From: Sandra Edwards **On Behalf Of** Planning Scanning
Sent: 20 August 2019 09:35
To: Zac Denton <Zac.Denton@arun.gov.uk>
Subject: RE: FAO Zac Denton. Carleton House, 15 Maltravers Street - external wall

Conservation Correspondence re: colour – 15/08/2019

Many thanks for holding off publishing a decision last week on application AB / 54 / 19 / L following our telephone conversation.

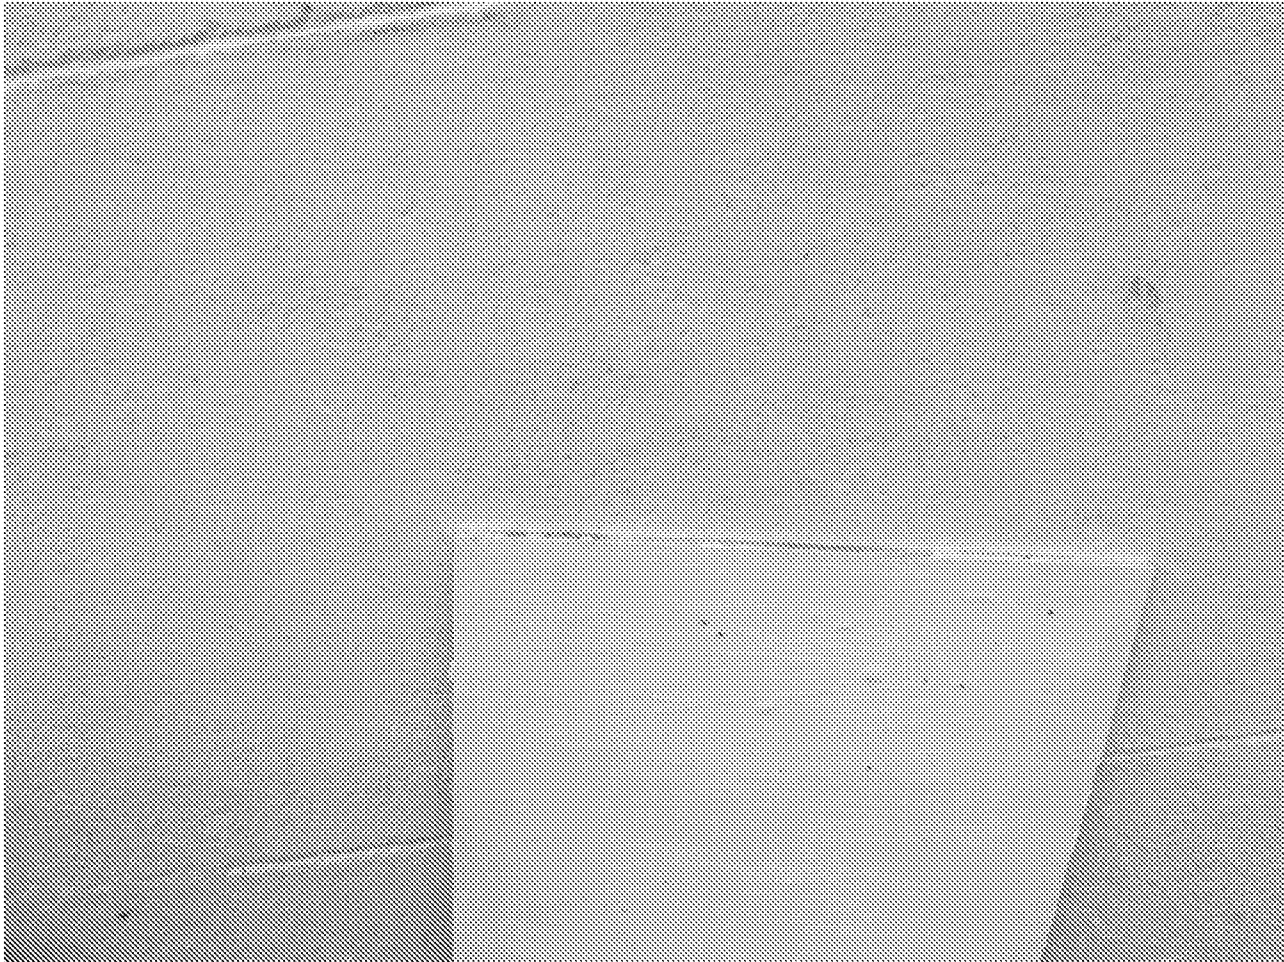
Thank you for the information regarding the revised colour. Based on the pictures provided (especially the second one) it appears to reflect the colour of the nearby building as is therefore acceptable.

And this is my painted board against the house at the top of Bakers Arms Hill (mentioned in your email)
